## DECISION DELEGATED TO HEAD OF PLANNING

**Application No:** H08-0852-25      **Applicant:** Mrs K M Baxter  
**Proposal:** Demolition of Existing Barns & Erection of 2 Dwellings  
**Location:** Belnie House Farm Buildings Belnie Lane Gosberton  
**Terminal Date:** 6th November 2025

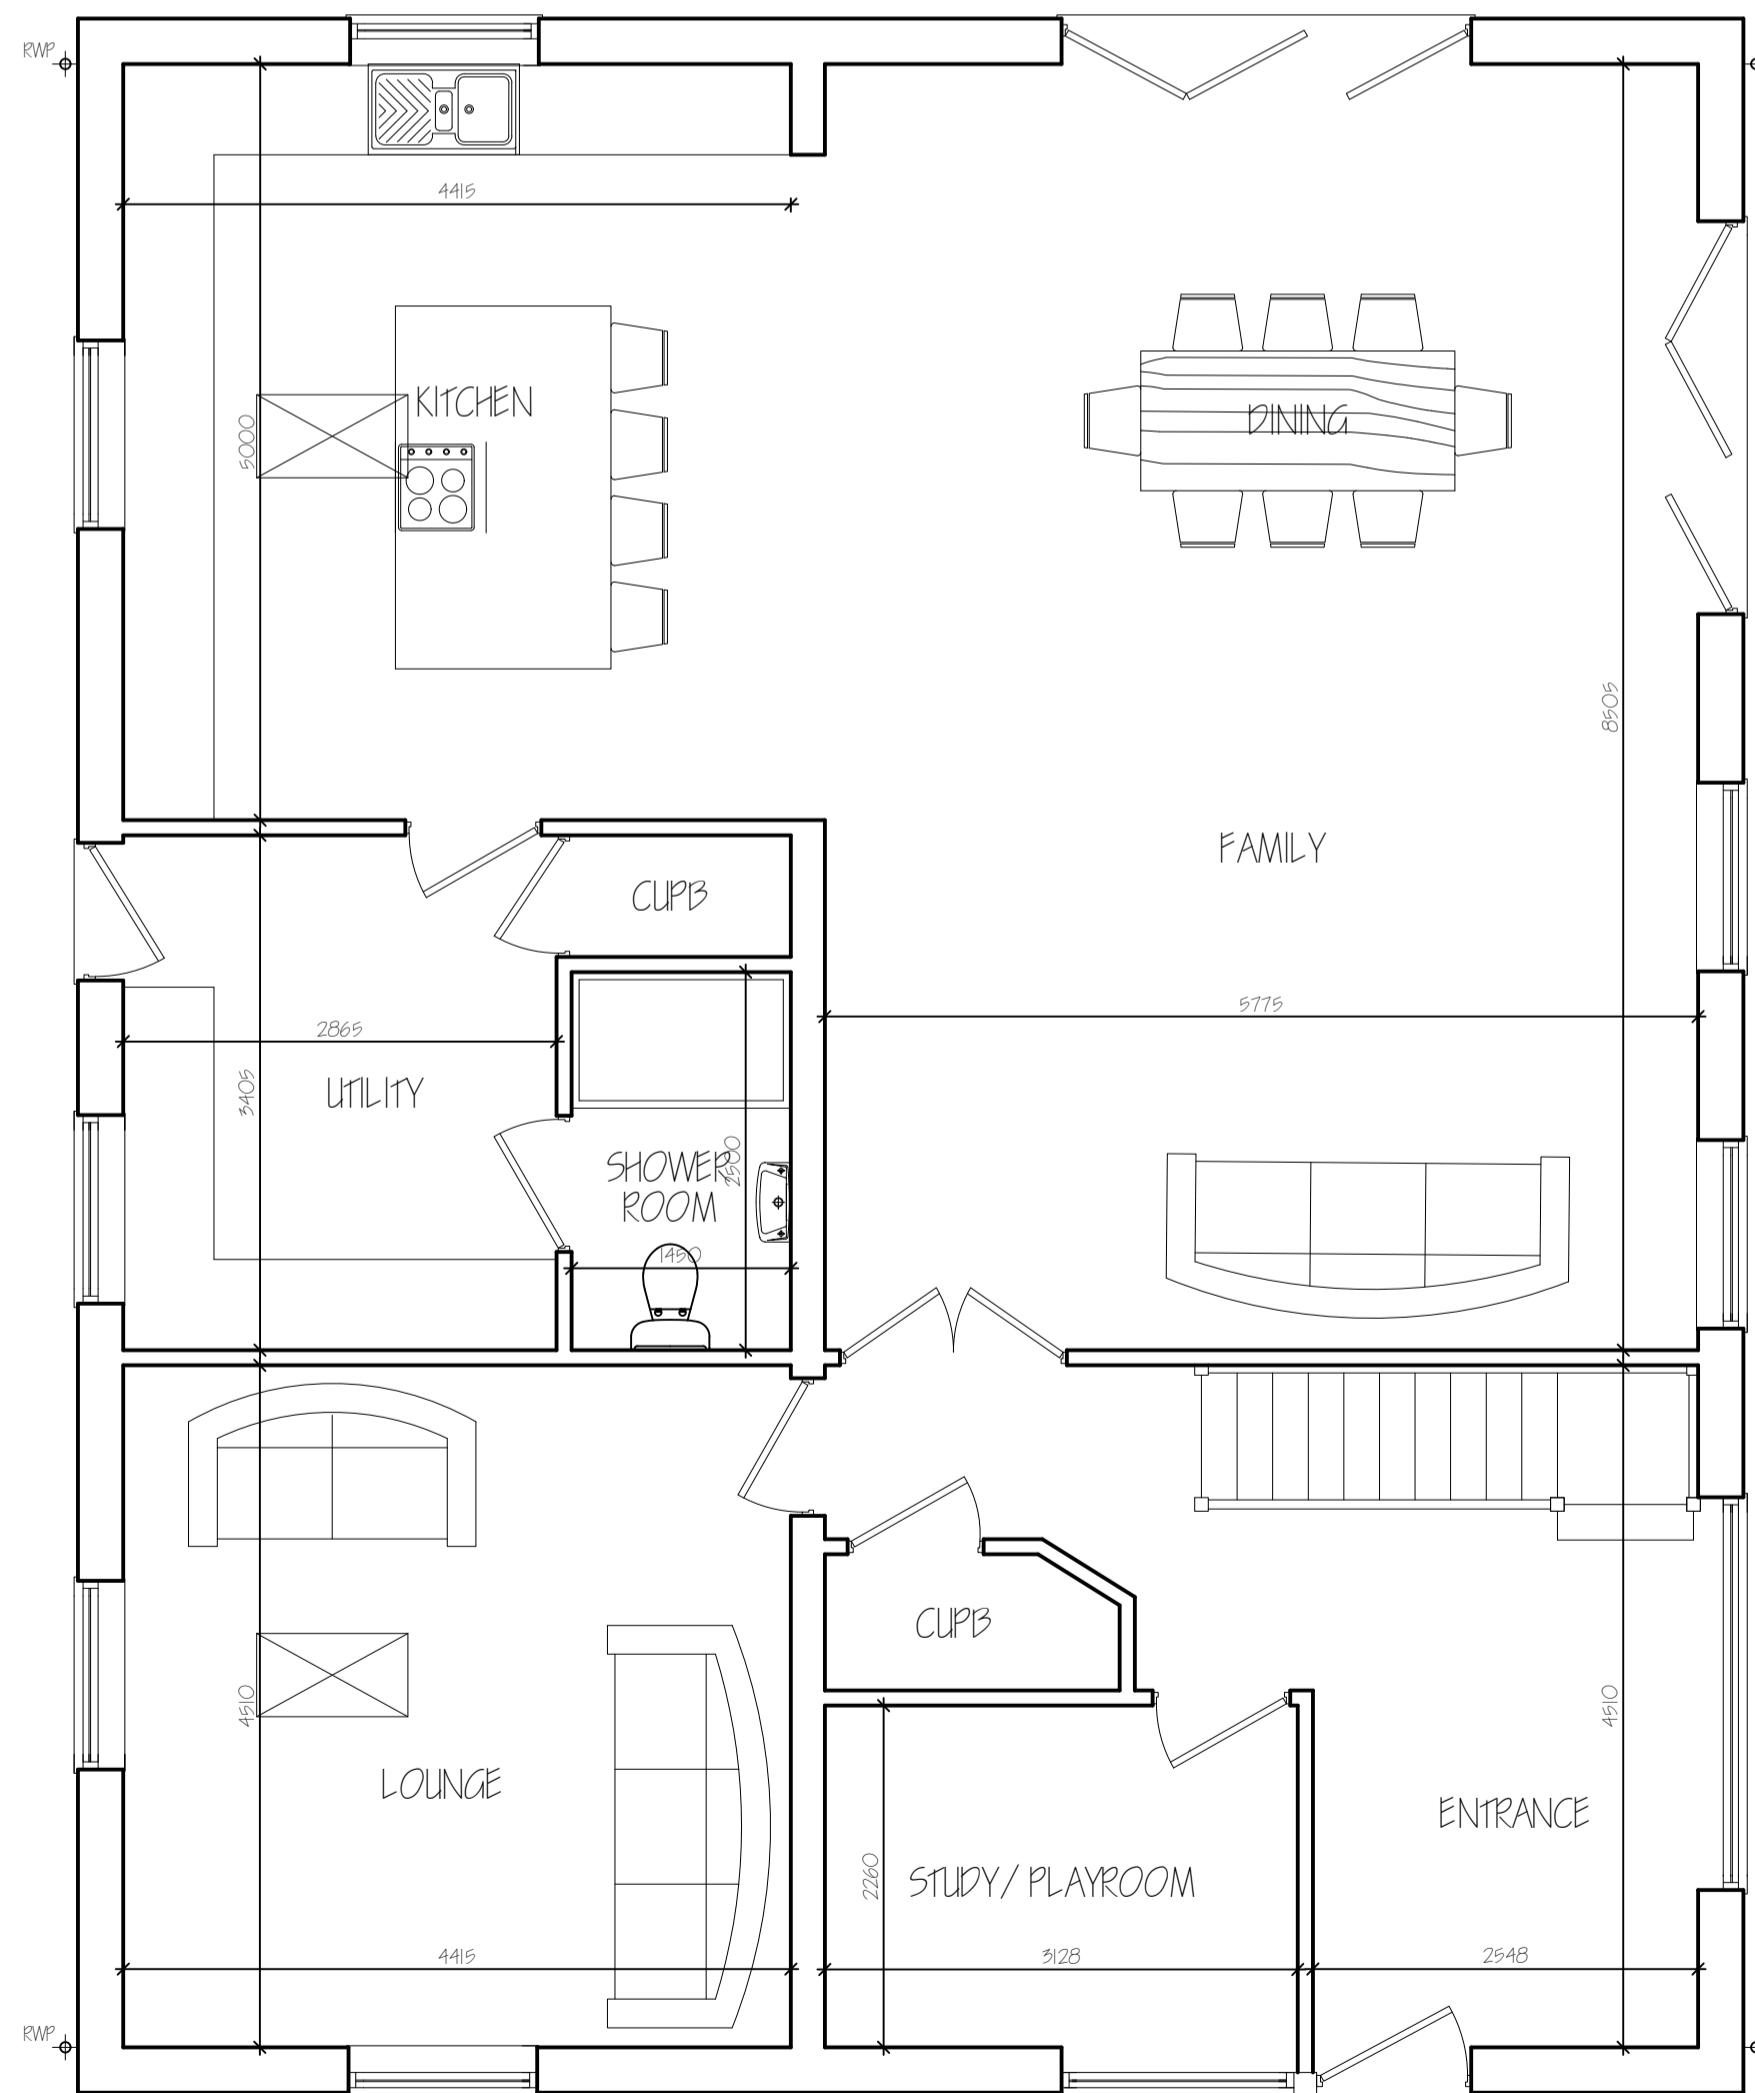
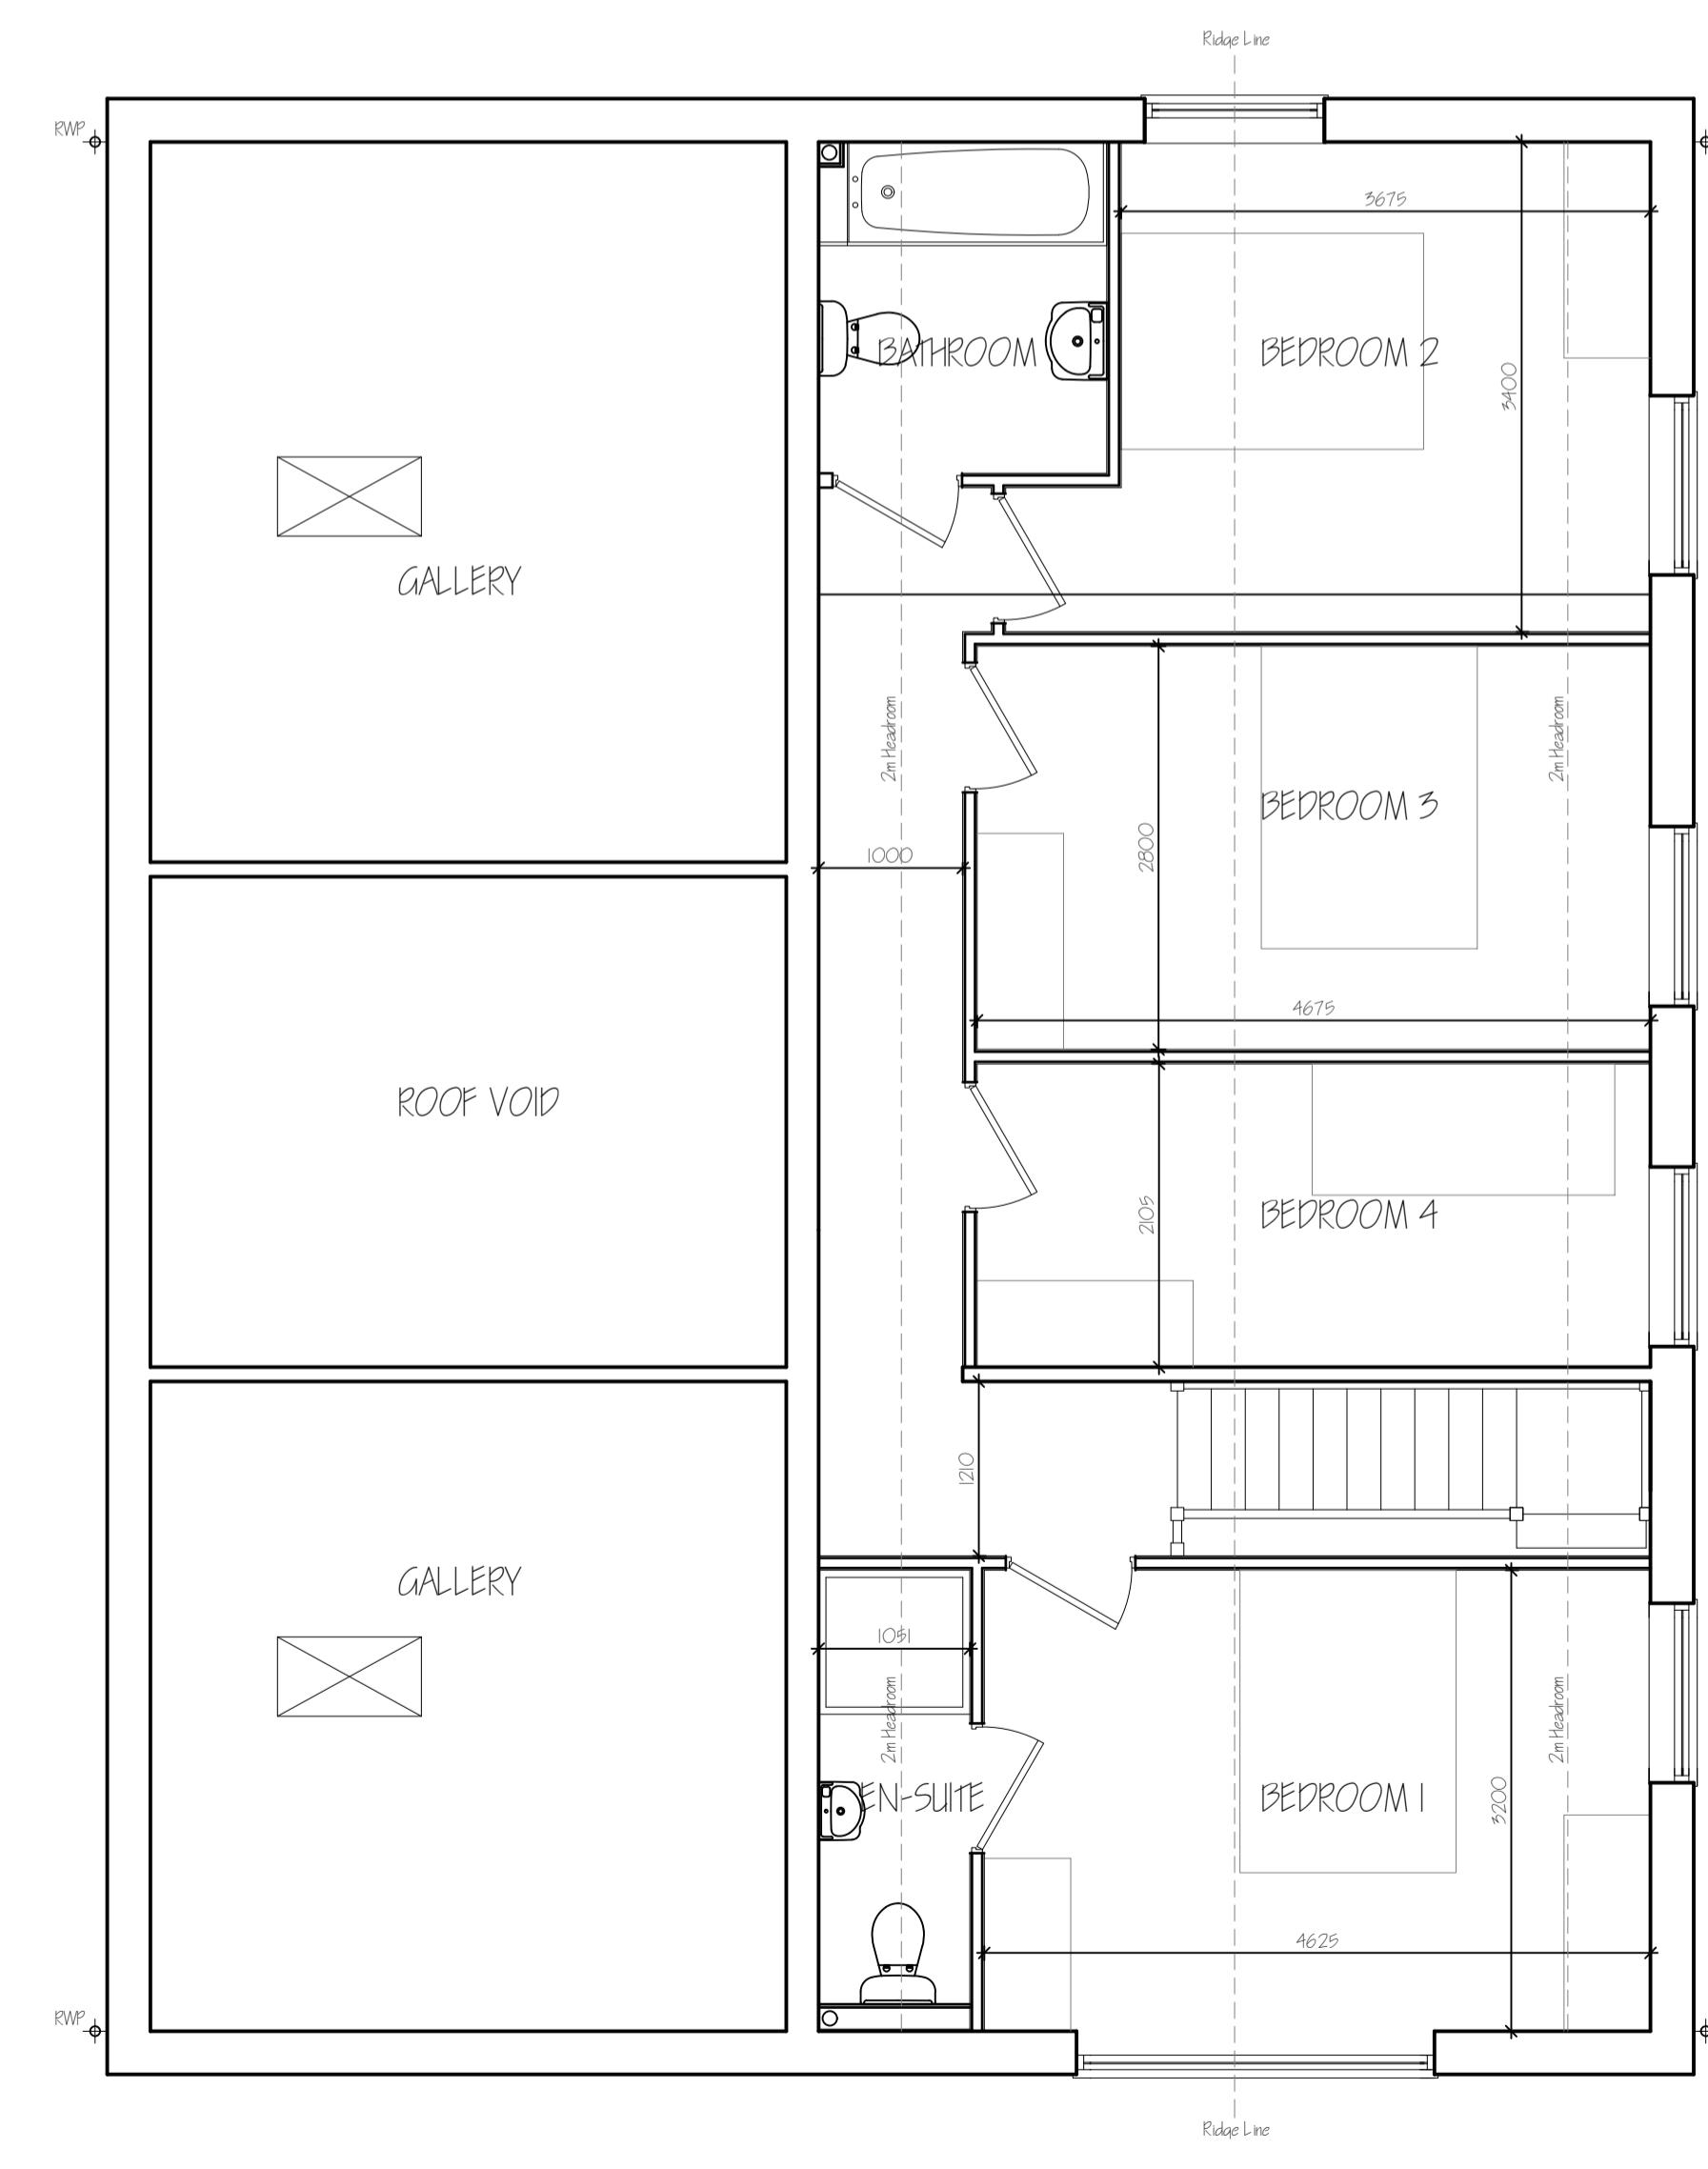
The current proposals seek to demolish the existing buildings within the site and install 2 matching dwellings. For example, both dwellings would feature a gable end roof form and a sloping roofline on the proposed side extensions. The dwellings would each measure 11m by 13.7m, and 7.1m in height up to the roof ridgelines. The proposed materials are not indicated within the submitted elevation plans; however, the application form refers to facing bricks, tiles and aluminium windows and doors.

The submitted Planning, Design and Access statement fails to justify the design rational in terms of its appropriateness to this location. Notwithstanding this, it is considered likely that the design is based on the approved barn conversion that was allowed under approval H08-0970-24. For example, both dwellings would feature a gable end roof form and a side extension with a sloping roof form. Furthermore, the approved conversion was proposed to measure 10.8m by 14m, and 6.5m in height. As such, the proposed dwellings would be of a comparable scale and feature a similar roof form to one of the approved conversions within the site. There are some key differences though such as the inclusion of new brickwork and additional windows and doors, including a large glazed element on the south-eastern elevation.

The building footprints of the 2 dwellings would be slightly smaller than the footprints of the Class Q conversions. For example, the 2 dwellings would each feature a building footprint of 150.7sqm,

It is considered that through the siting, orientation, footprint and form of the proposed development, this would result in a more urbanising effect upon this part of the countryside than the Class Q approvals. This is considered to result in more harm to the character and appearance of the area than the previous approvals. Furthermore, the applicant has failed to demonstrate a clear or overriding justification as to why such a design would or should be considered acceptable in this location.

Whilst the proposed design bears some resemblance to one of the Class Q approvals, it is not considered to represent betterment over what has already been approved on this site, which was a more sympathetic and appropriate design in this rural and open countryside location and setting. As such, the proposal is considered to be contrary to the aims of Policies 2 and 3 of the Local Plan, and Paragraph 187(b) of the NPPF.

**Post-Development Plan
Post-Development Map**

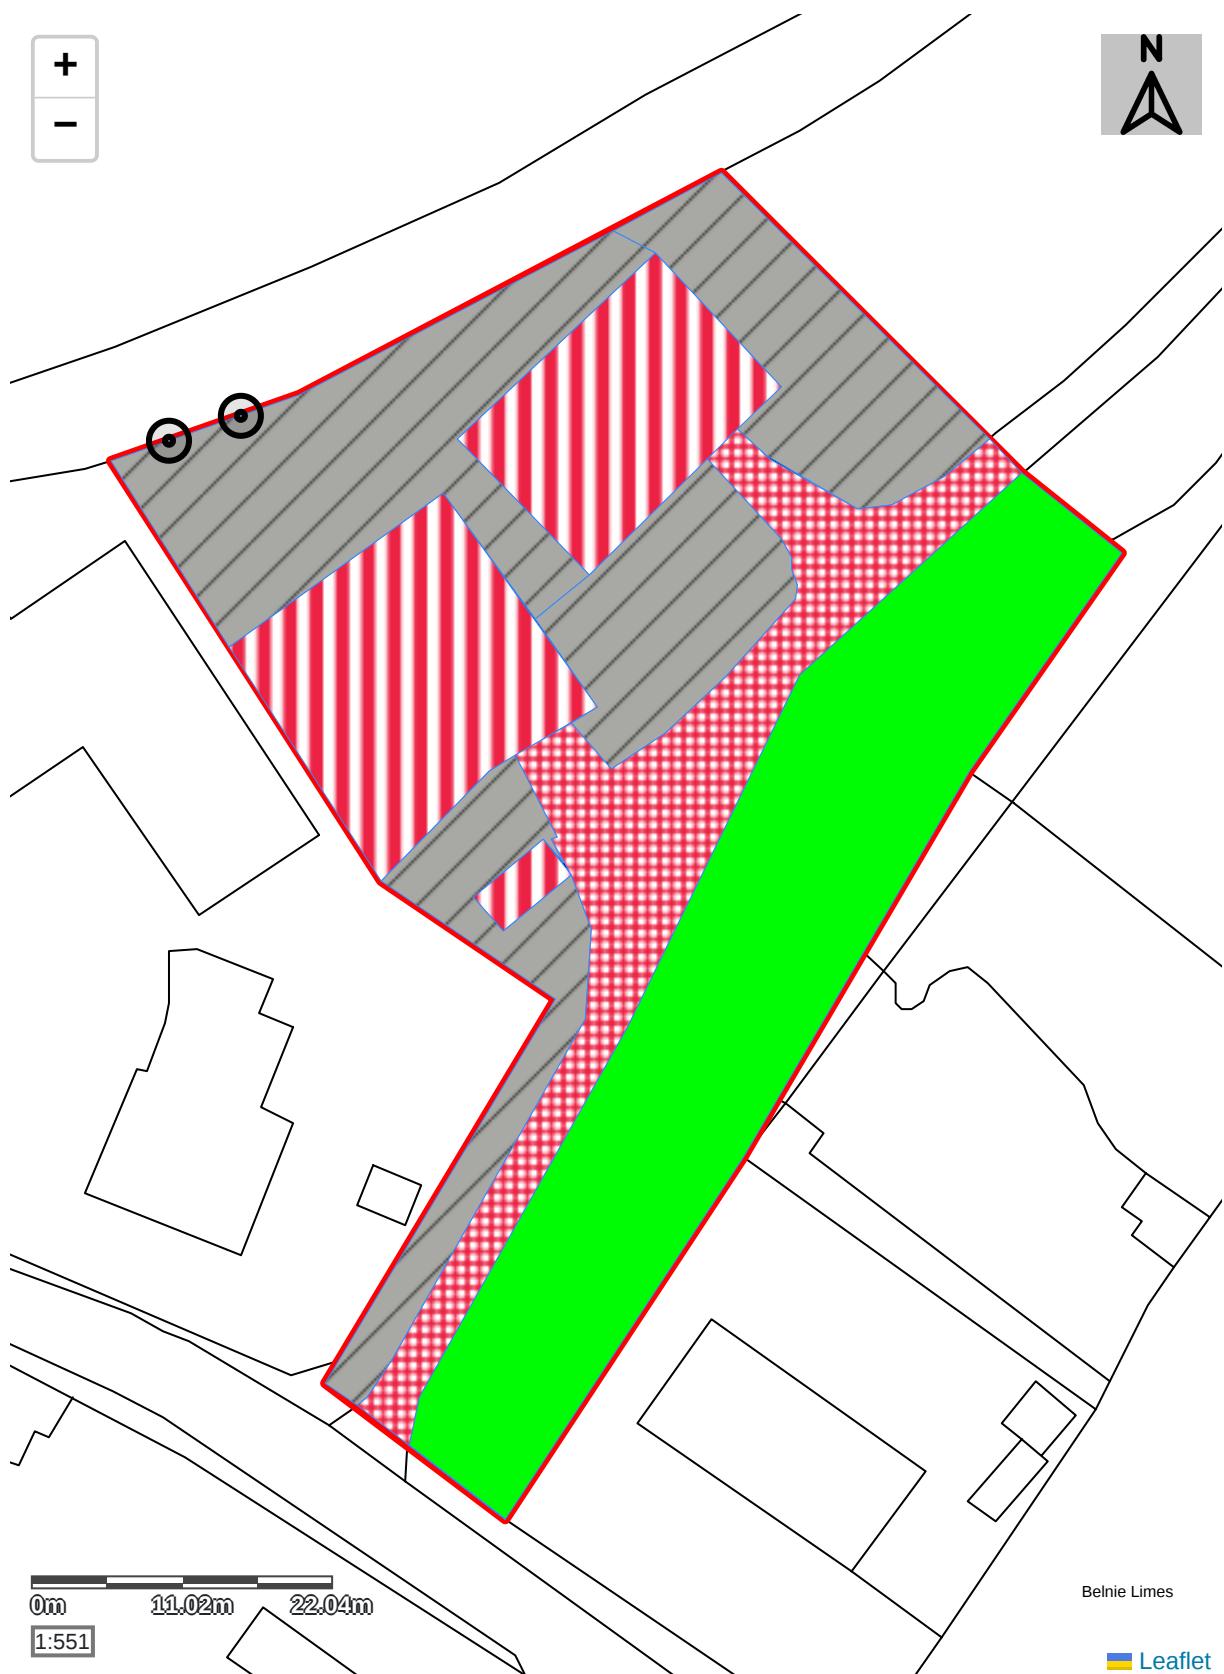
Ecology Officer: There has been sufficient evidence provided to determine this application and we are confident that 10% mandatory net gain can be achieved onsite. A BNG plan and HMMP will be required pre-commencement as well as an alteration to the BNG post-development plan map. The 3 proposed trees in the north corner of the site will need to either be removed (resulting in not achieving 10% net gain) or moved to land owned by the landowner not within the domestic curtilage of the dwelling if they wish for the trees to be counted as individual trees in the metric and not as vegetated garden (following guidance on page 58 of the BNG user guide). This will need to be altered on the post-development habitat map pre-commencement for transparency in the BNG application. We support all mitigation and enhancement recommendations provided in the PEA and further request that they be set as a condition at discharge. We request that greater provision for other bird and bat species is required to improve the biodiversity outcomes of the site and mitigate the loss of habitat post development. Therefore, we request that at least 2 integrated bird boxes and 1 integrated bat box are included in the dwellings.
